19th February 2025

Council refers to Department of Planning, Housing and Infrastructure (DPHI)'s request for comment on the modification Application No. SSD-17424905-Mod-2 (Pymble Ladies Collage – Grey House Precinct) at 20 Avon Road, Pymble on 3rd February 2025.

Figure 46 | Landscape area (Source: Applicant's RtS 2022)

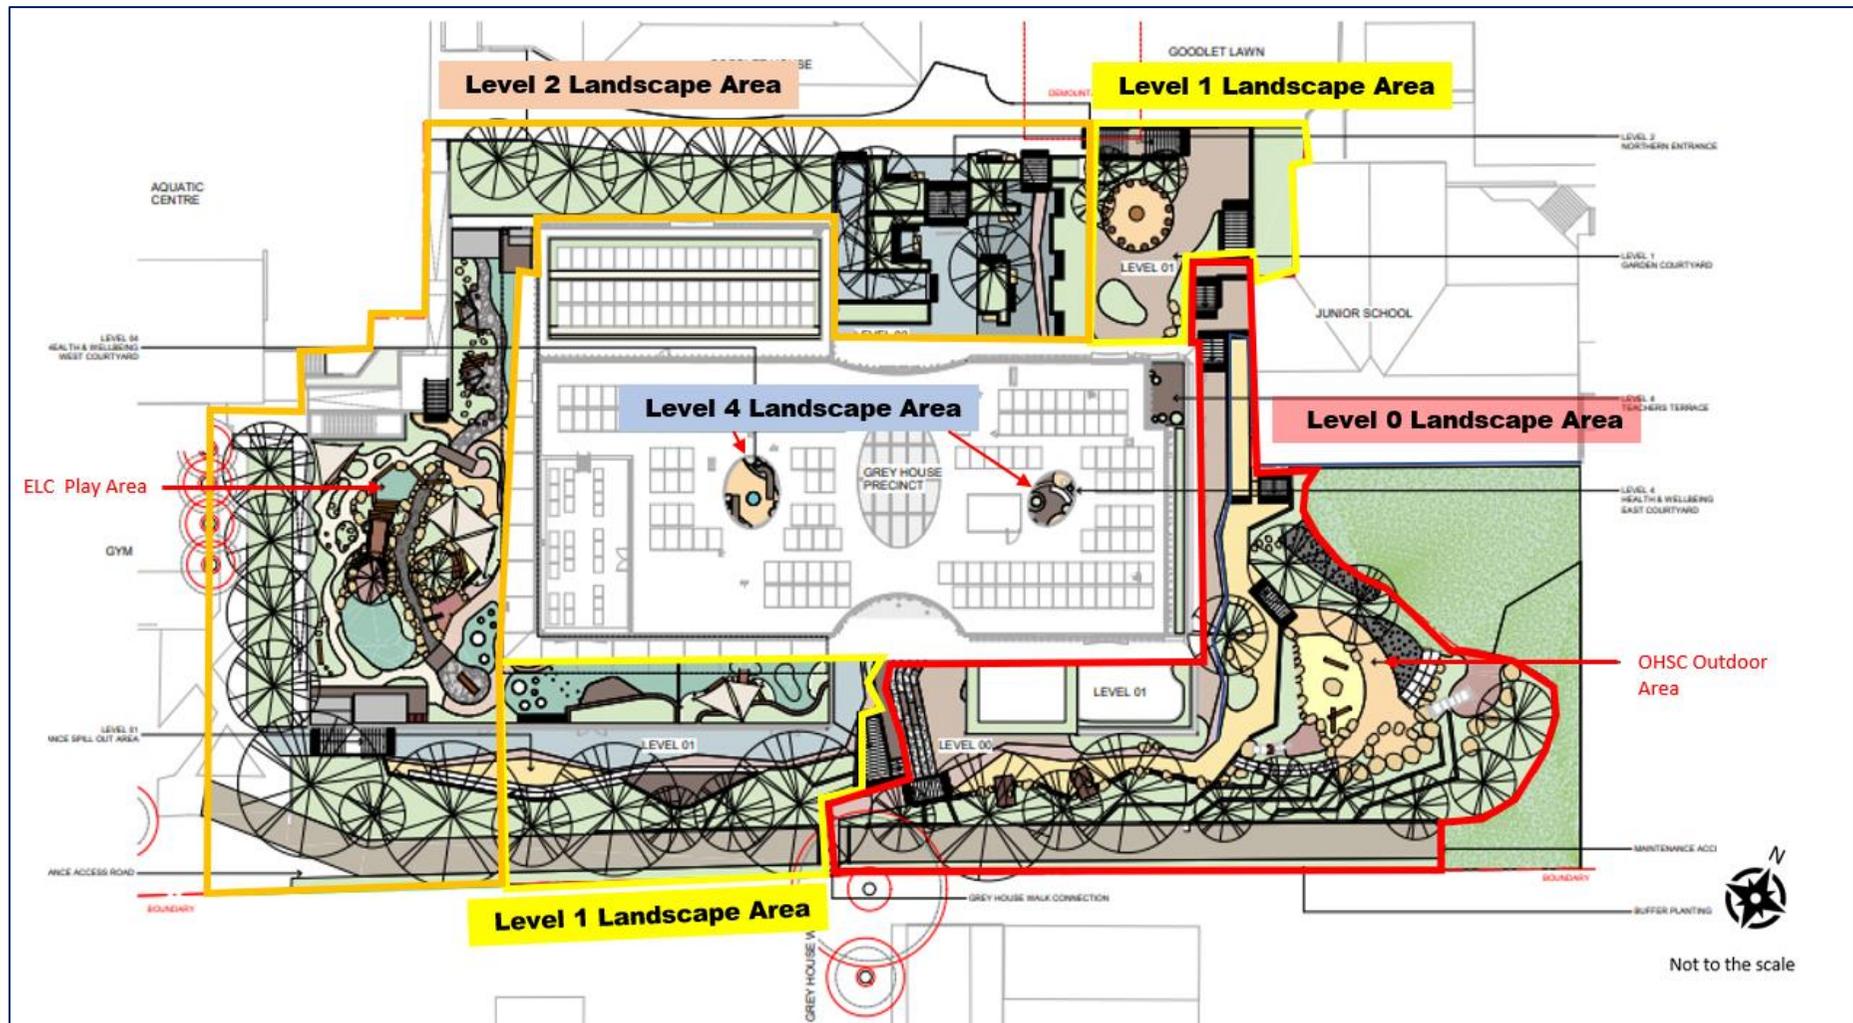
"Some of the canopy and large understorey tree planting which were indicated on the approved landscape plans are proposed to be modified to be of much smaller tree planting of 5m in height at maturity. While acknowledging concerns raised concerning overshadowing of properties this is a substantial change from the original approved planting scheme in both scale and density of planting.

The proposed substitution of Eucalyptus saligna (Sydney Bluegum) and Syncarpia glomulifera (Turpentine) and Allocasuarina torulosa (Forest Oak) and Glochidion ferdinadii (Cheese Tree) and Eleaocarpus reticulatus (Blueberry Ash) for Ceratopetalum gummiferum (NSW Christmas Bush), Eucalyptus ficifolia "Summer Red", will reduce the predicted overshadowing from some of the proposed tree planting in this area. However, the planting proposed is very domestic in scale and will not provide substantial visual buffer to this area of the development.

It is suggested other larger species which achieve a greater height while still not excessively overshadowing the properties, could be explored as alternatives. For example, species such as Eleaocarpus reticulatus or similar locally occurring native species.

There also seems to be no reason in terms of overshadowing to substitute the Eleaocarpus reticulatus as indicated on the approved plans. These are setback from the boundary and while are indicated as being capable of 15m in height, this species normally (in the local area) typically achieves a height of 6-8m. and does not have a dense or spreading canopy.

As a general comment the height estimates at maturity indicated for some species are at the extreme end of expectations compared that which is typical of growth of these species in the local area including Allocasuarina torulosa and Glochidion ferdinandii. as well as Eleaocarpus as noted.

Eucalyptus ficifolia "Summer Red", is not a locally occurring native species. A locally occurring naïve species should be considered.
